Our ref: WSU Indigenous Centre of Excellence (SSD-64916225)

Subject: Response to Submissions

ATTACHMENT 1 – KEY ISSUES / FURTHER INFORMATION REQUIRED

Client: WESTERN SYDNEY UNIVERSITY  
 Drawing title: PLAN OF DETAIL AND LEVELS OVER LOT 100 DP816829  
 "CAR PARK P1" FIFTH STREET, PARRAMATTA

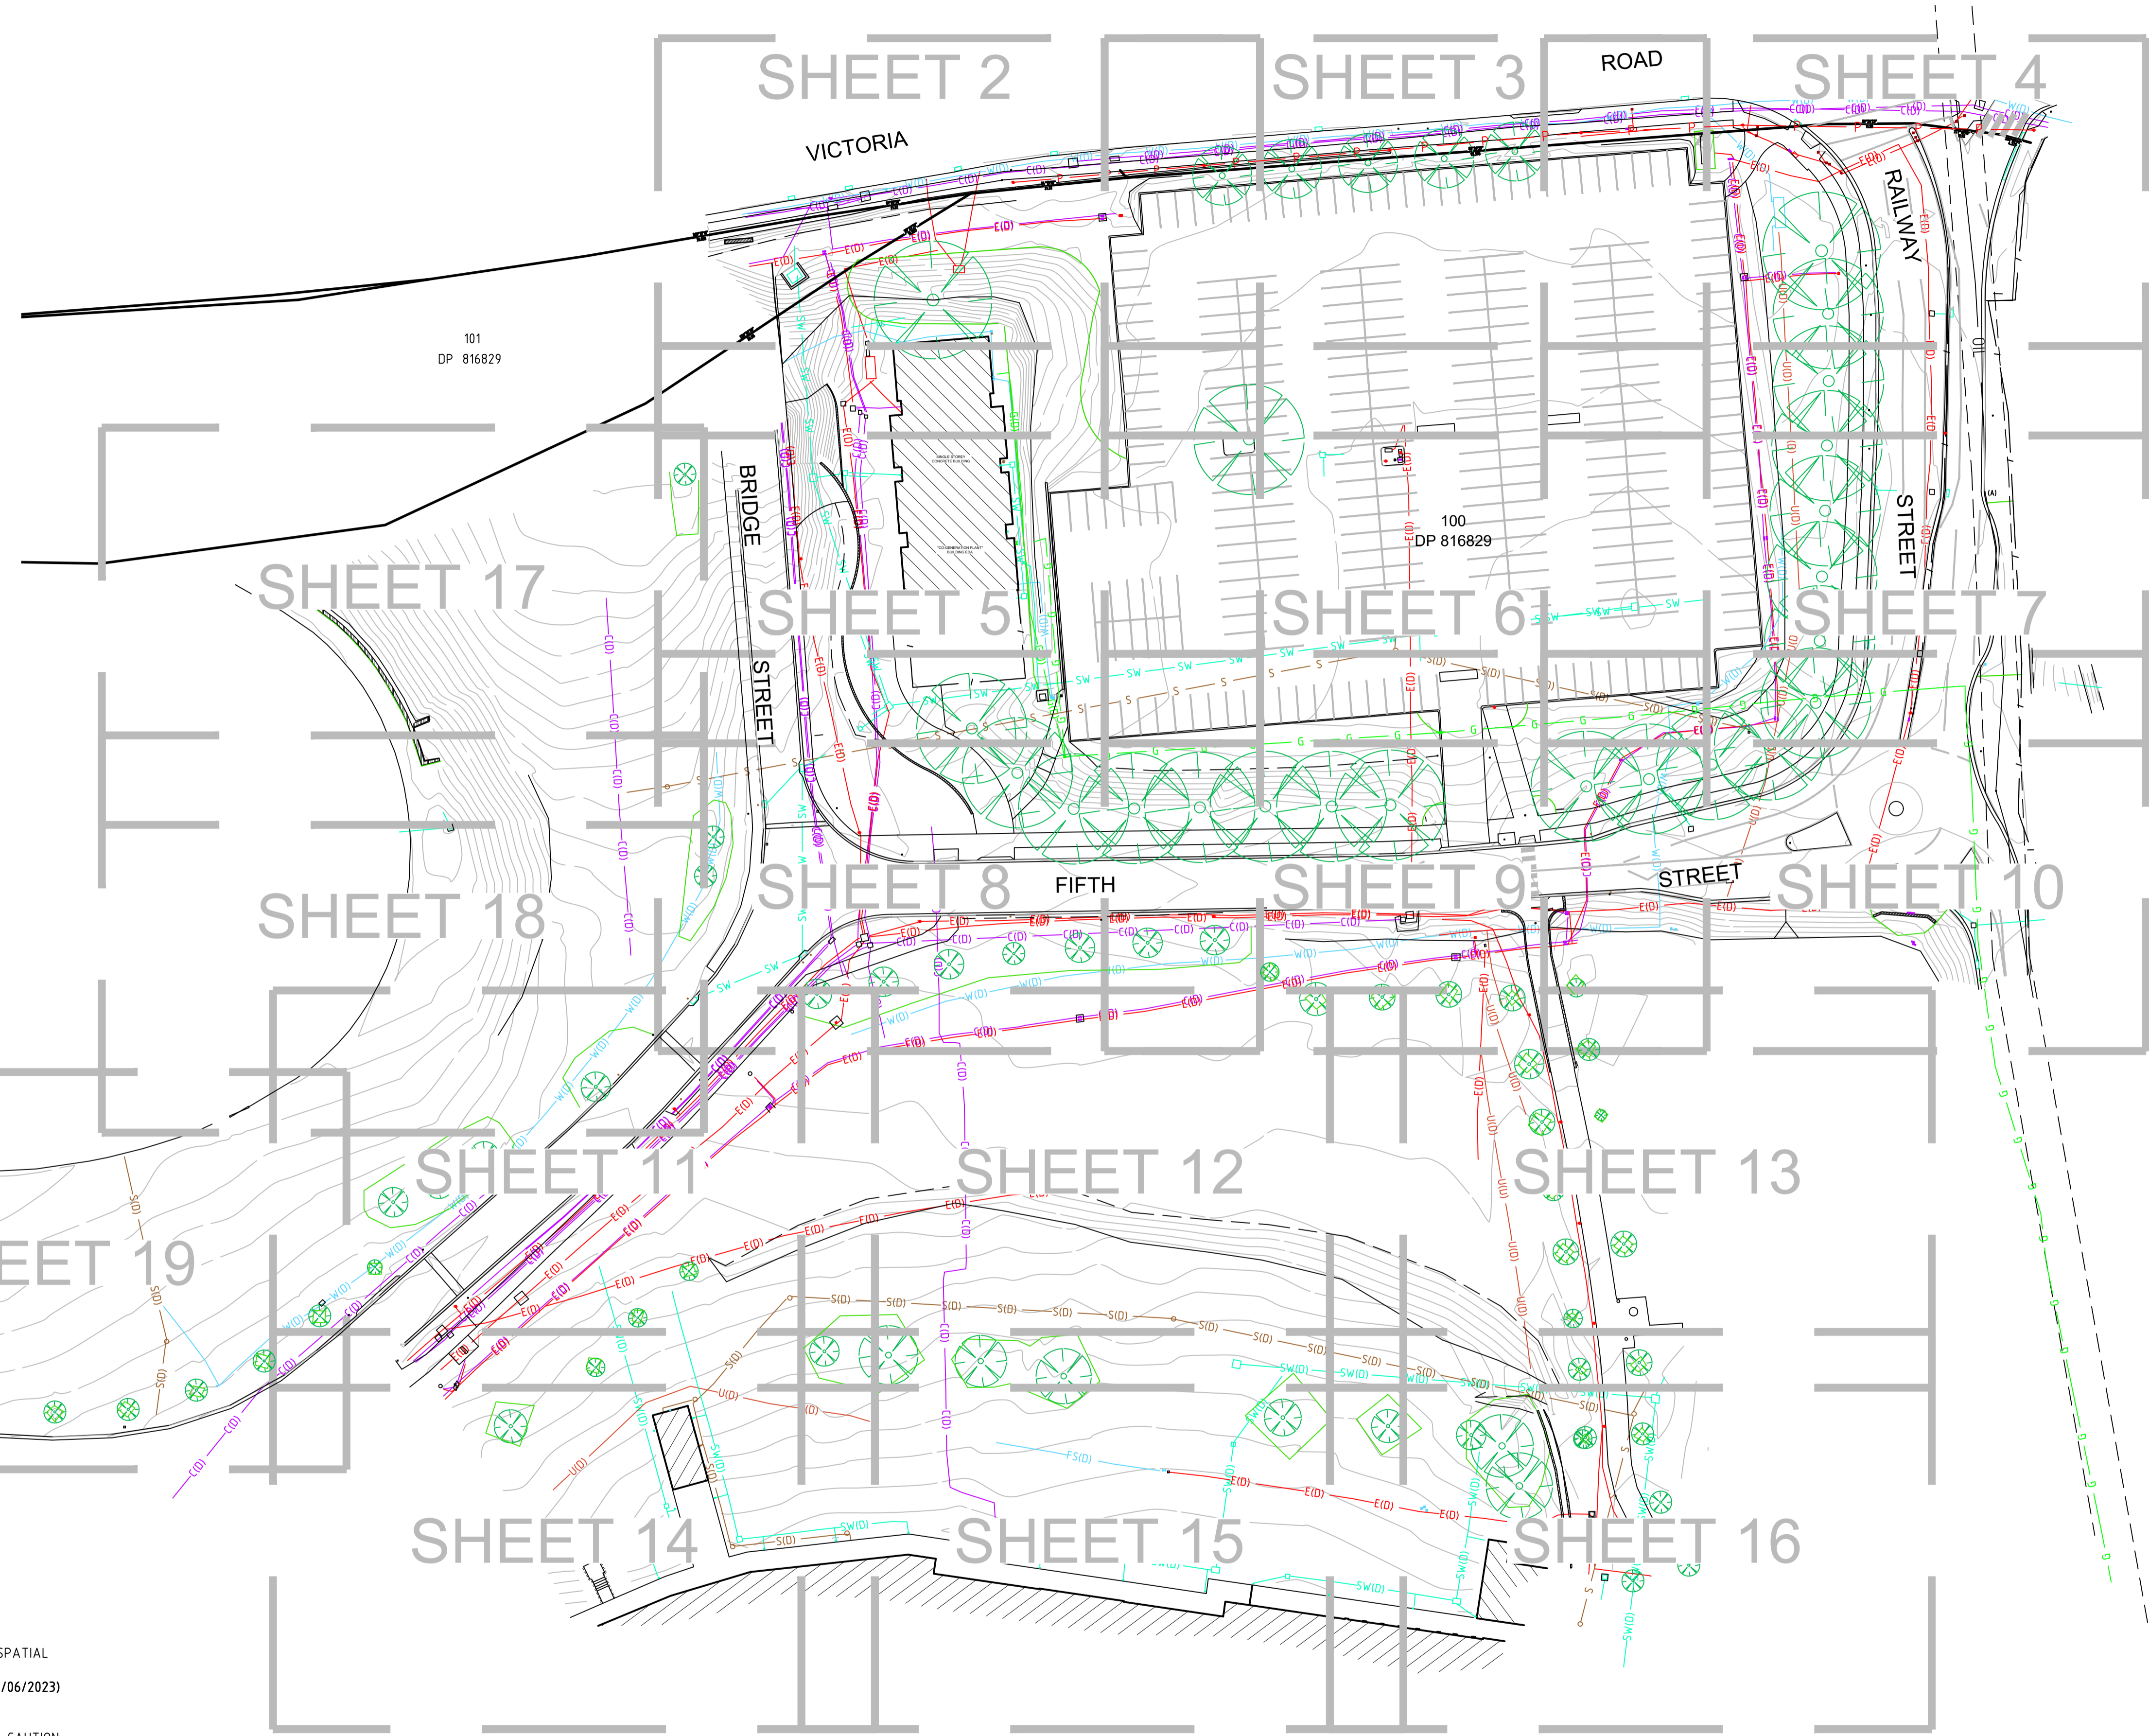
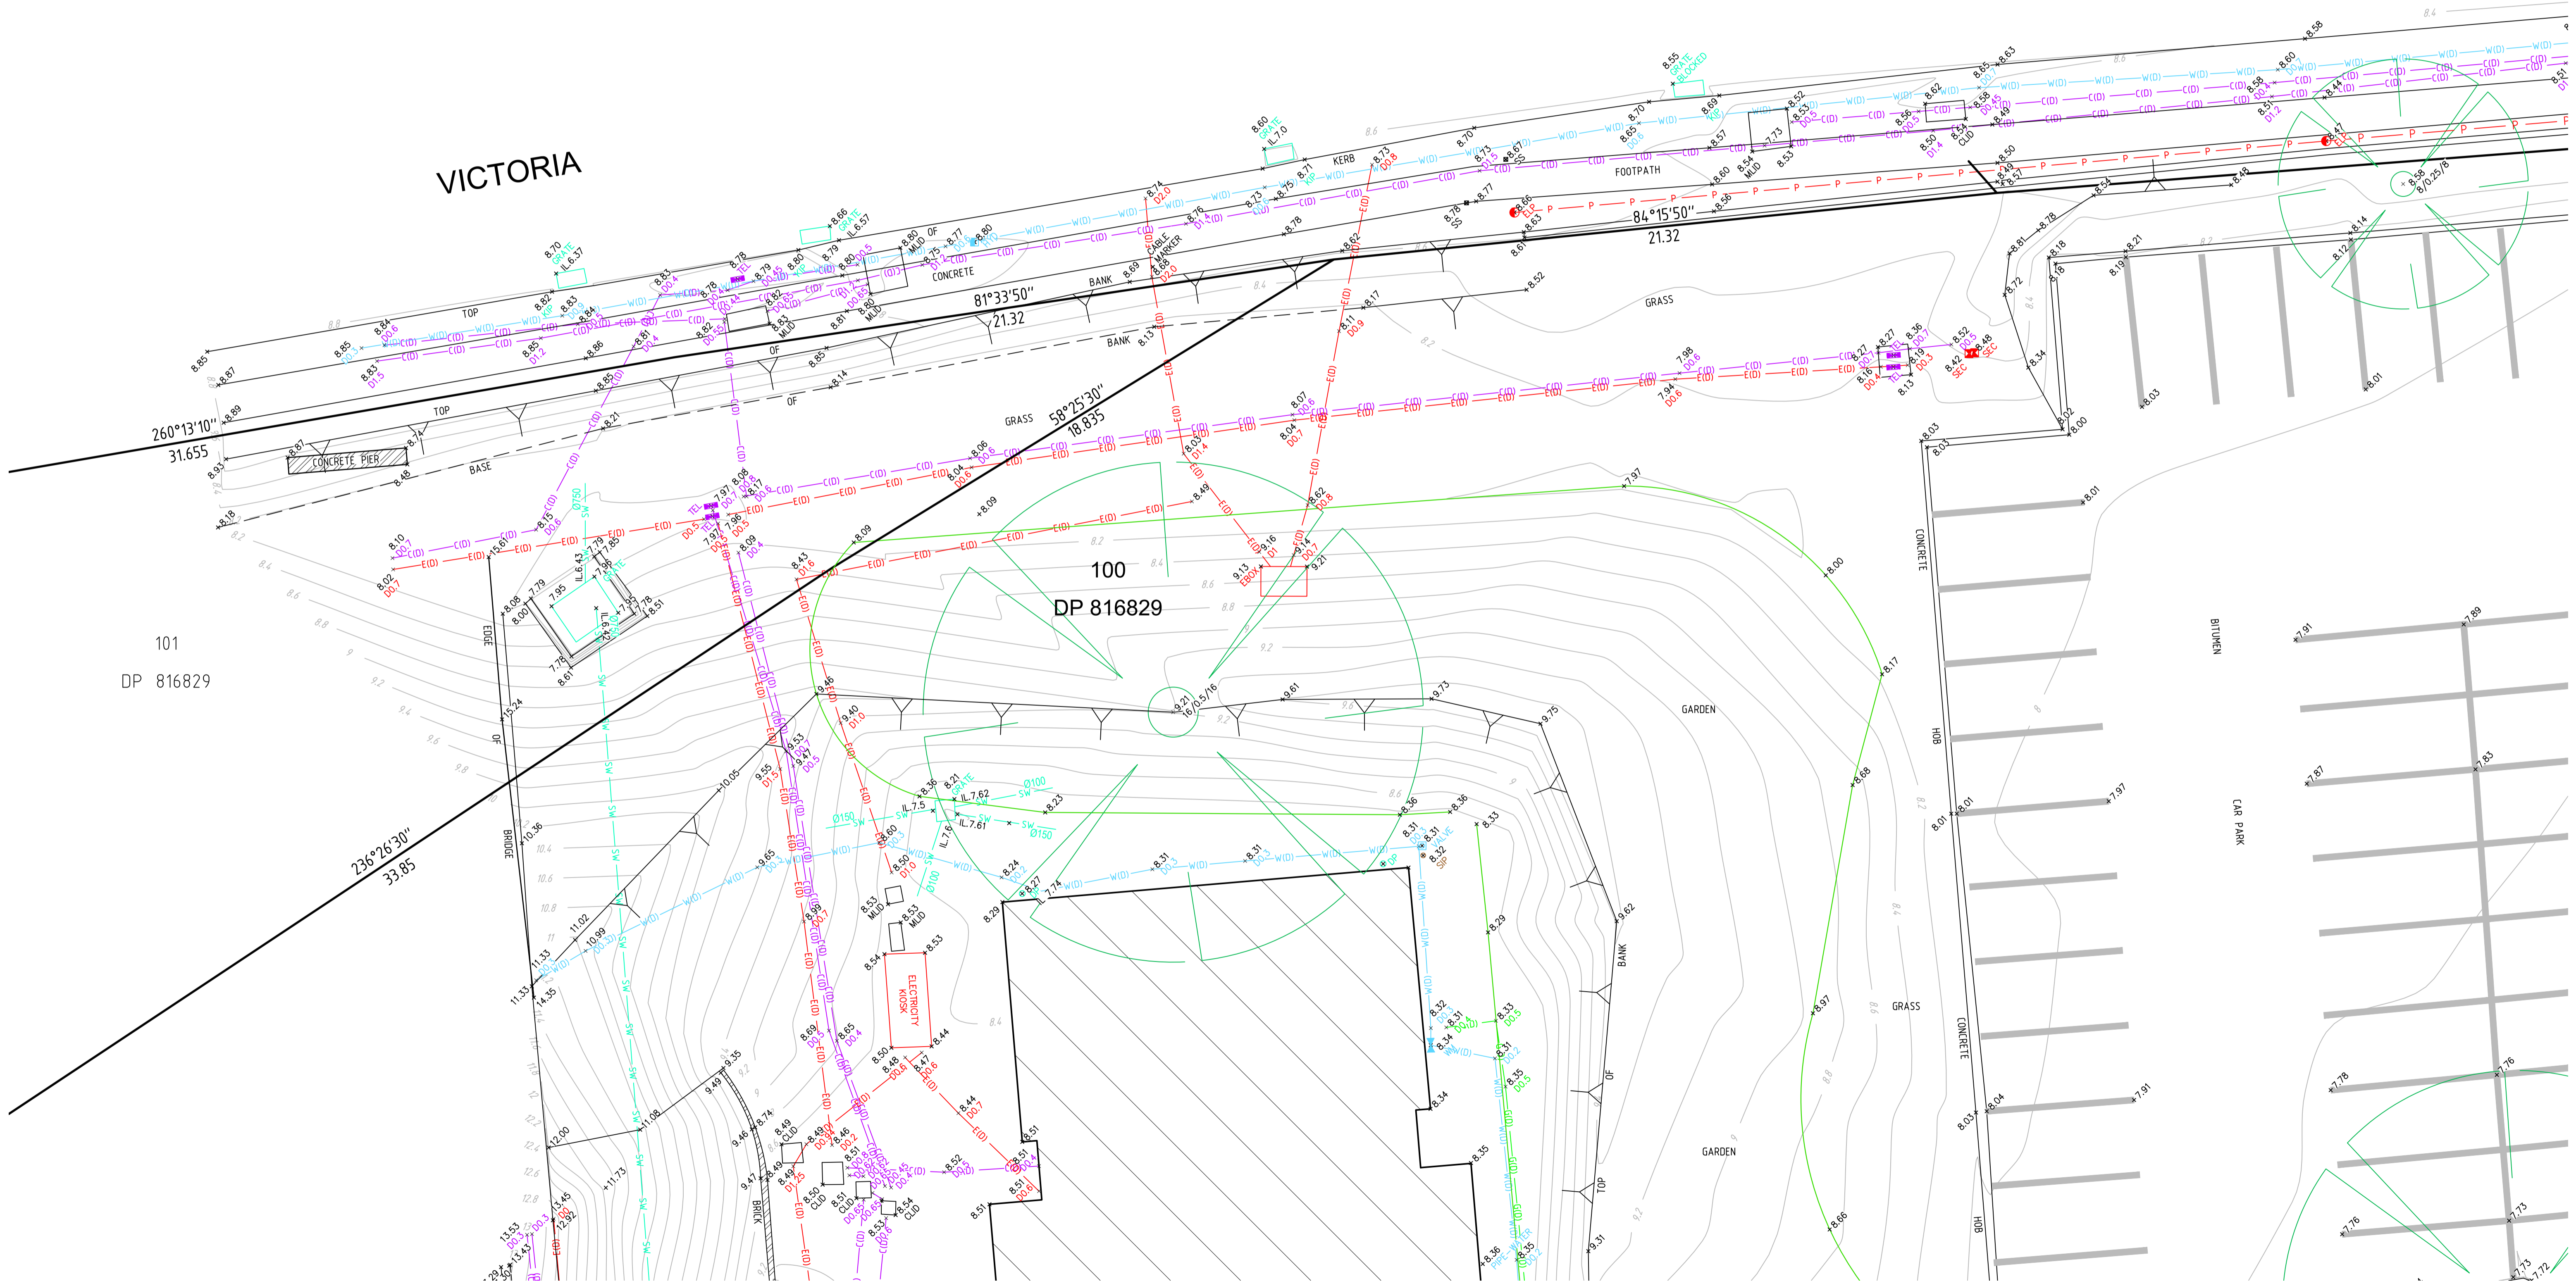
- As per Crown Lands' advice, the proposed development footprint encompasses both Lot 100 and Lot 101 DP 816829, both identified as Crown Land. Works plans show works within both lots. Landowner's consent has not been provided for Lot 101 DP 816829 and must be provided prior to any determination in accordance with Section 23 of the Environmental Planning and Assessment Regulation 2021.
- Revise all documentation to identify the site correctly.
